# CITY OF ALBUQUERQUE

RE: **Mercado el Milagro**  
**10000 Central SW**  
**Conceptual Grading Plan Stamp Date: 9/6/19**  
**Drainage Report Stamp Date: 9/6/19**  
**Hydrology File: L09D042**

Based on the submittal received on 9/9/19 the above-referenced submittal is approved for Site Plan for Building Permit.

MERCADO EL MILAGRO
 NEW SITE PLAN
 10000 CENTRAL AVENUE SW
 ALBUQUERQUE, NEW MEXICO 87121

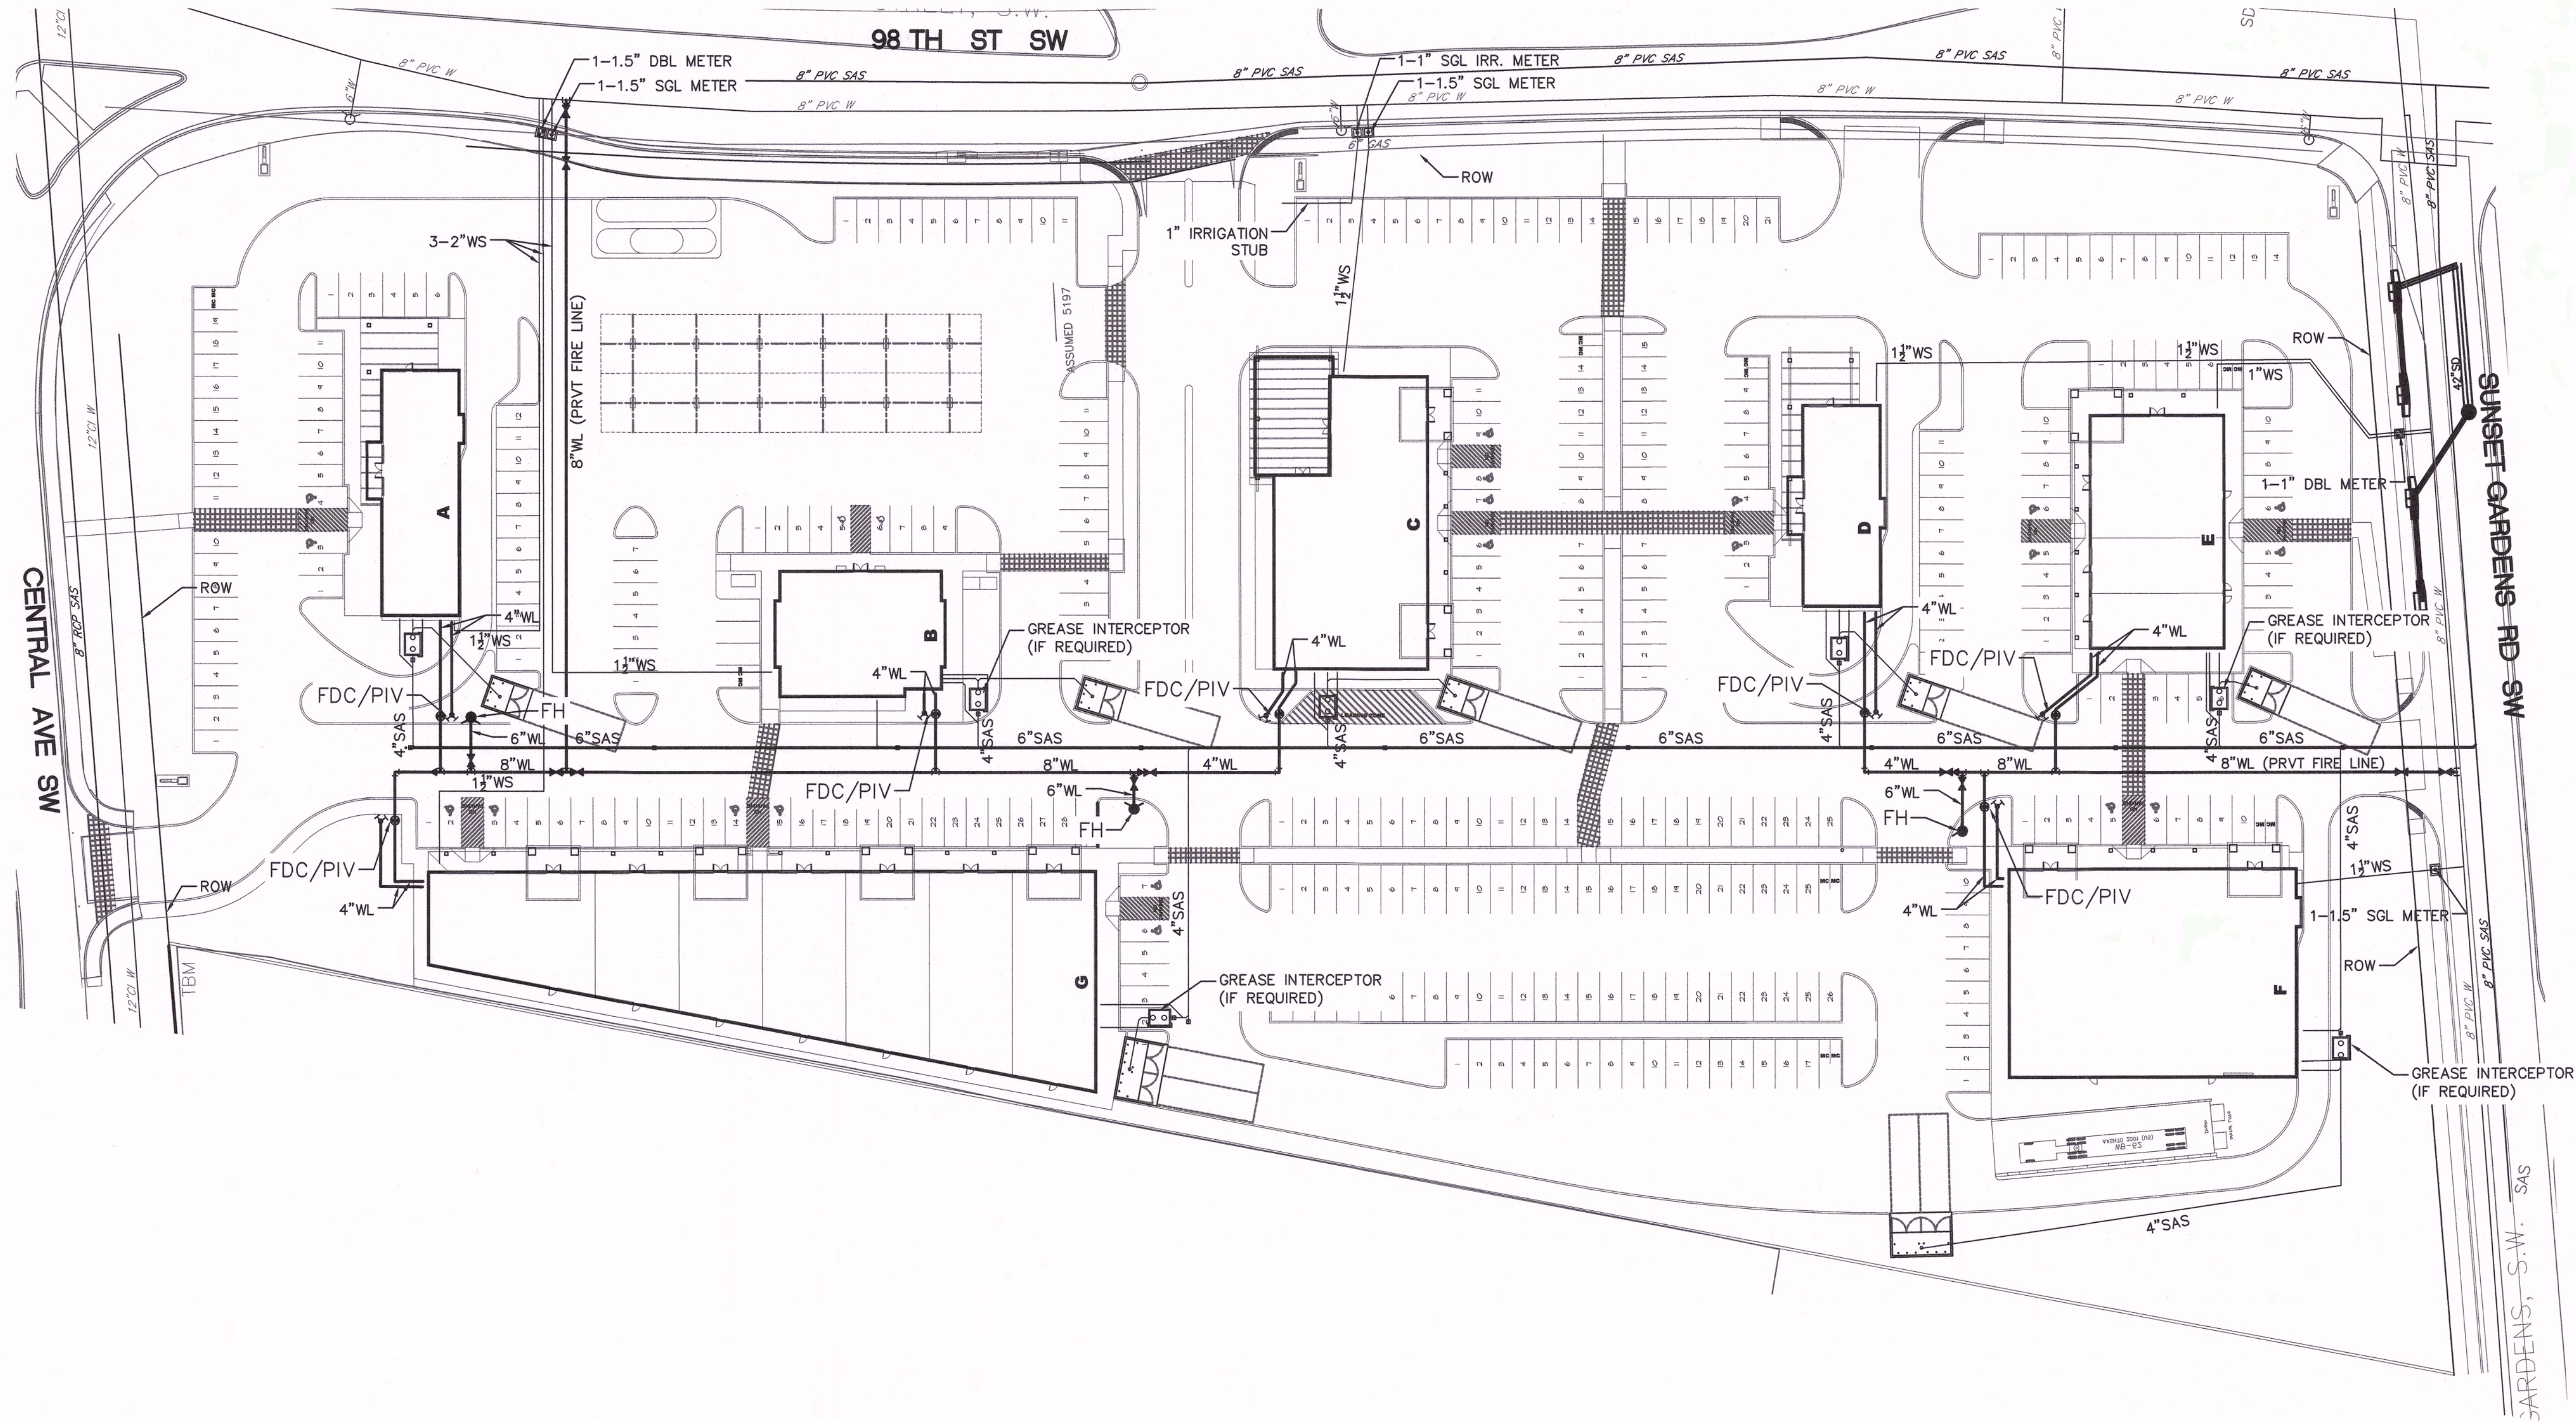
1. Additional detail is required on the retaining wall:
  - a. A structural design for wall with showing how a reversed footer will be built on the property line.

- b. Grades in the adjacent lot, top of wall, and bottom of wall elevations, showing tie-in at property line along the length of the wall.
  - c. A detail of the spillover structure showing how flows will be accepted into this site.

- d. A cross-lot drainage easement is needed for undeveloped flows along the interim condition flow path.
2. Remove all "Conceptual" markings.
3. As a reminder, if the project total area of disturbance (including the staging area and any work within the adjacent Right-of-Way) is 1 acre or more, then an Erosion and Sediment Control (ESC) Plan and Owner's certified Notice of Intent (NOI) is required to be submitted to the Stormwater Quality Engineer (Doug Hughes, PE, [jhughes@cabq.gov](mailto:jhughes@cabq.gov), 924-3420) 14 days prior to any earth disturbance.
